City of Albuquerque Stormwater Construction Site Inspection Report

Project Name:	Mister Carwash				
Location:	98th & Volcano				
Site Contact Name & Agency	Victor - Corner Stone	ESC File No.	K08E004		
	victor@cornerstonem.com	NPDES Id. No.	NMR1002LG		
Inspection Date:	02/06/20	Start/End Time:	0910/0930hrs		
CoA Stormwater Inspector:	Timothy E. Sims				
Construction Phase:	earthwork				
Type of Inspection:	☒ Regular	☐ Storm Event	☐ Post Storm Event >0.25"	☐ 311/Complaint	☐ Follow Up

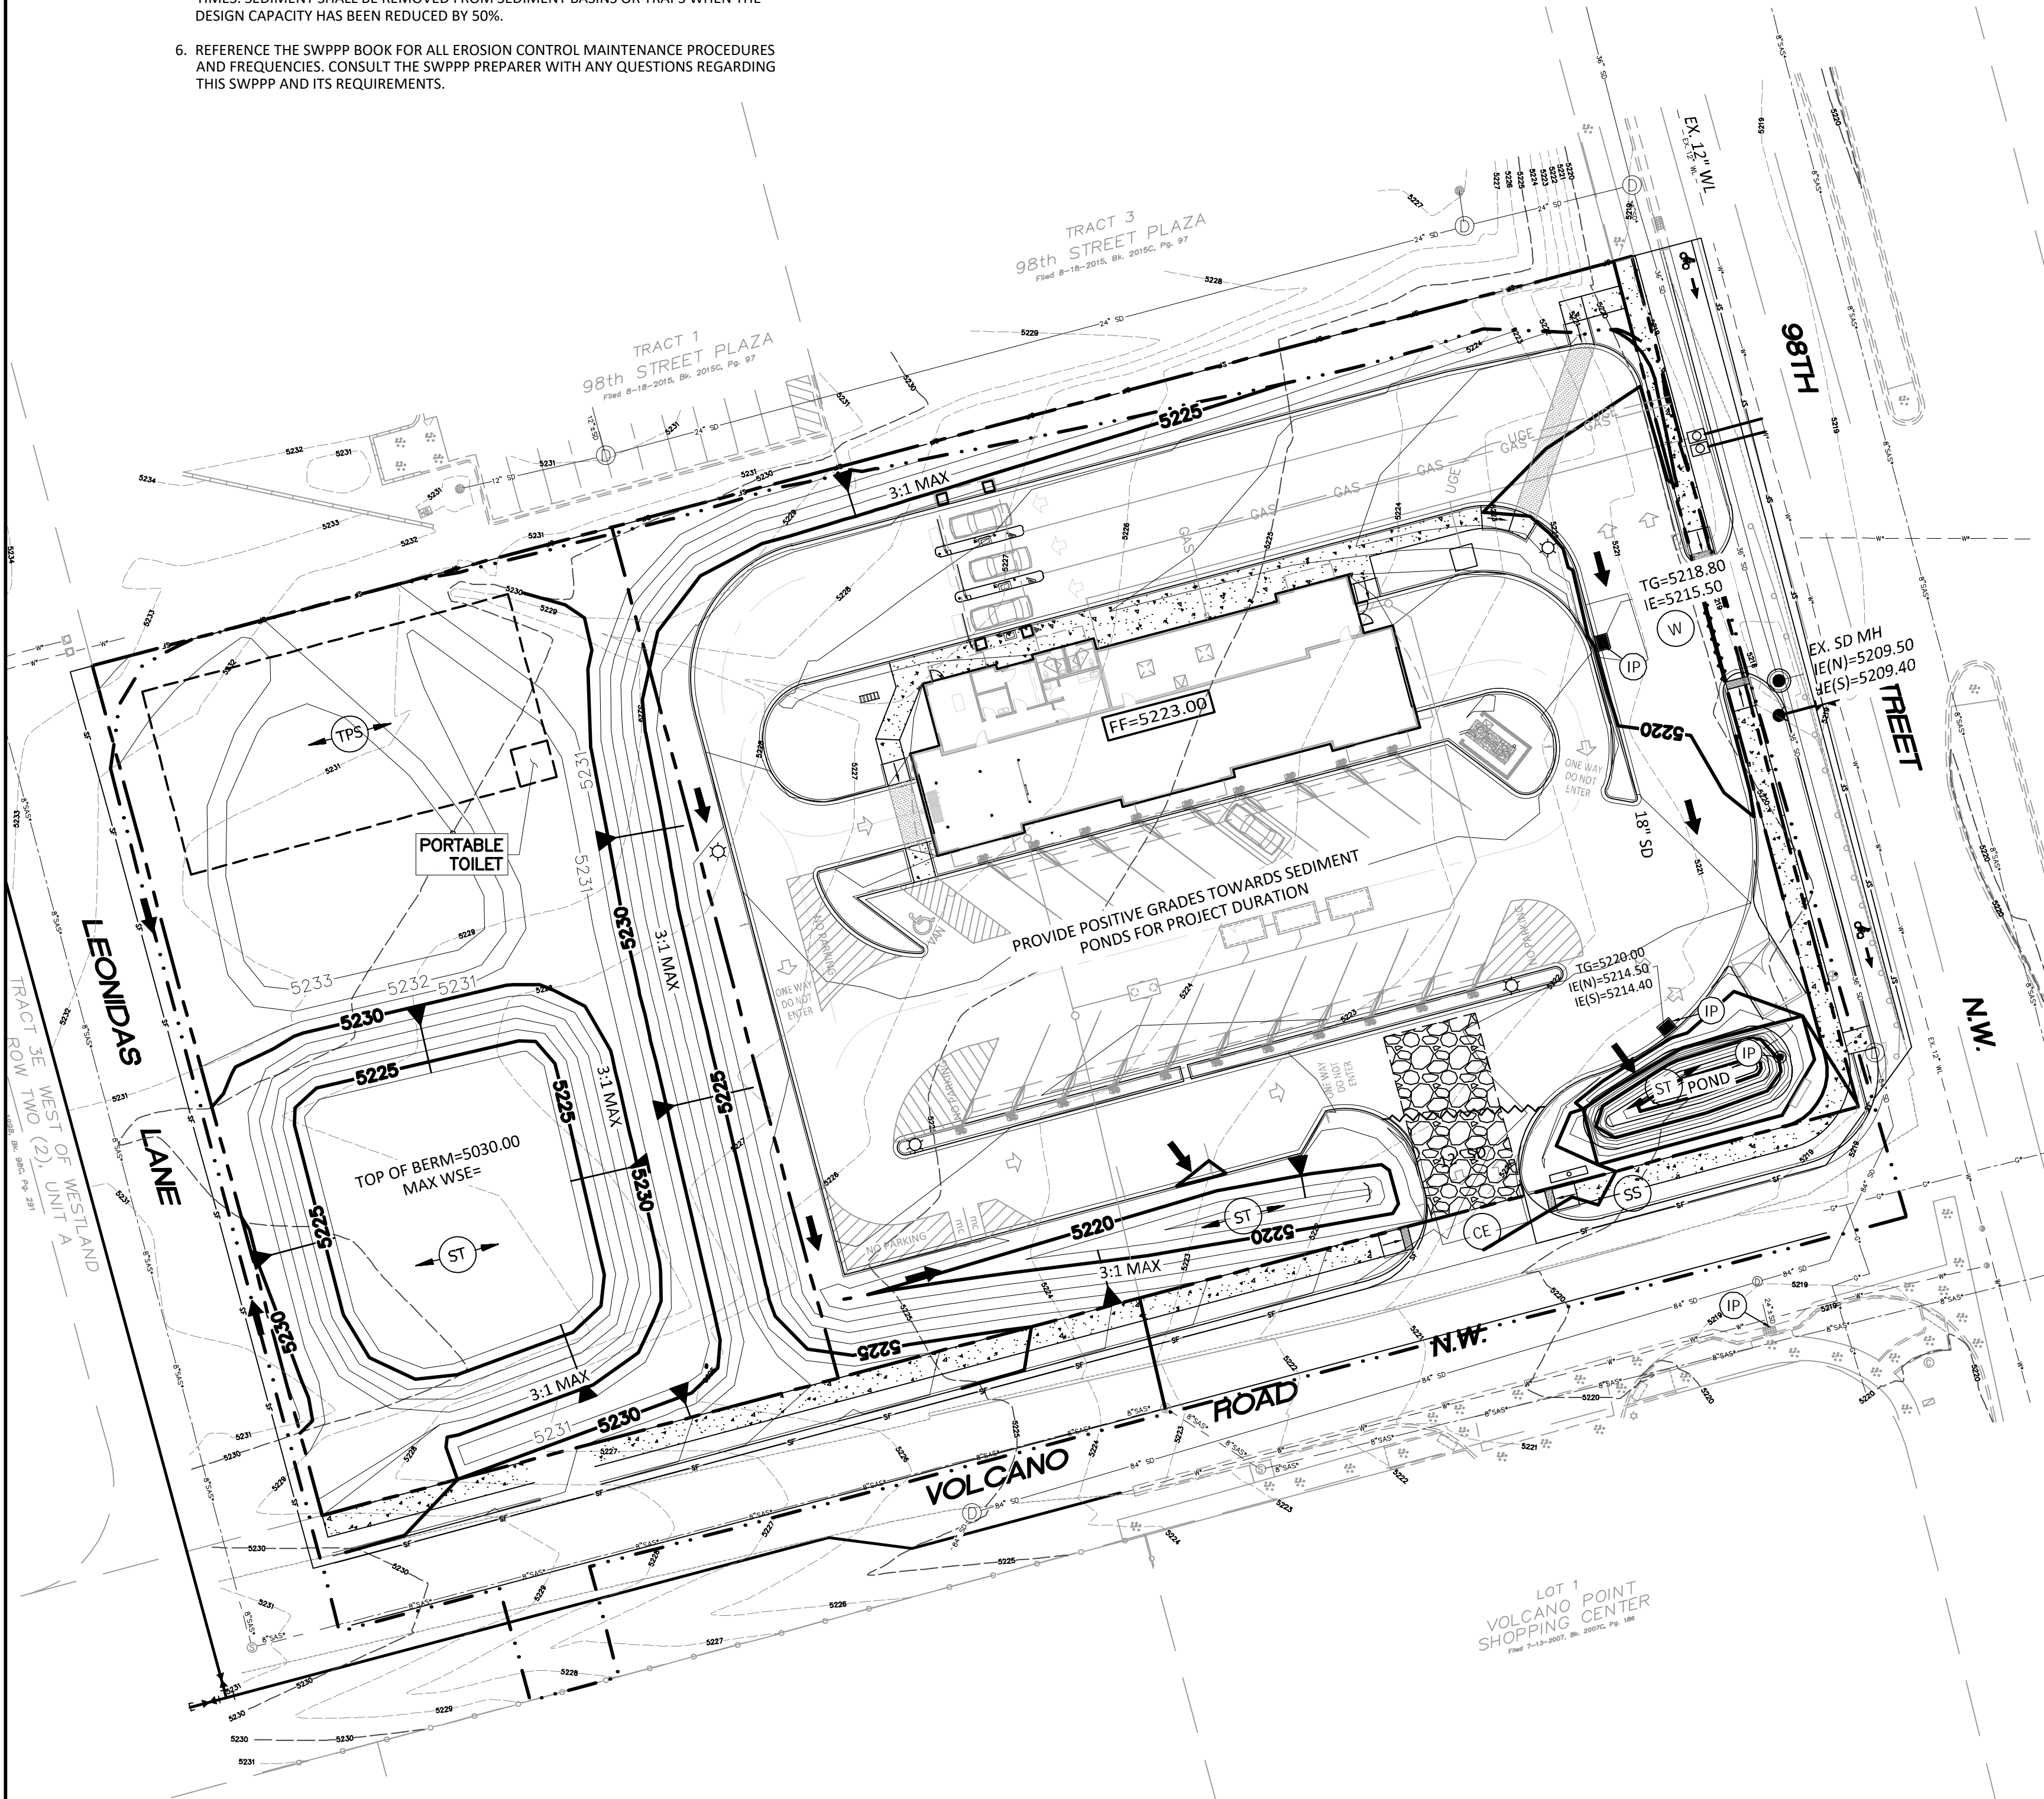
Item Number	Deficiency/ Corrective Action			
1	Install BMP per approved plan.			
2	Provide NPDES posting for this site.			
3	Provide latest SWPPP self-inspection report.			
2.1	Discharge off site? (Y/N)	No		
4	Self Inspection Reports	requested	Latest report Date:	not on file
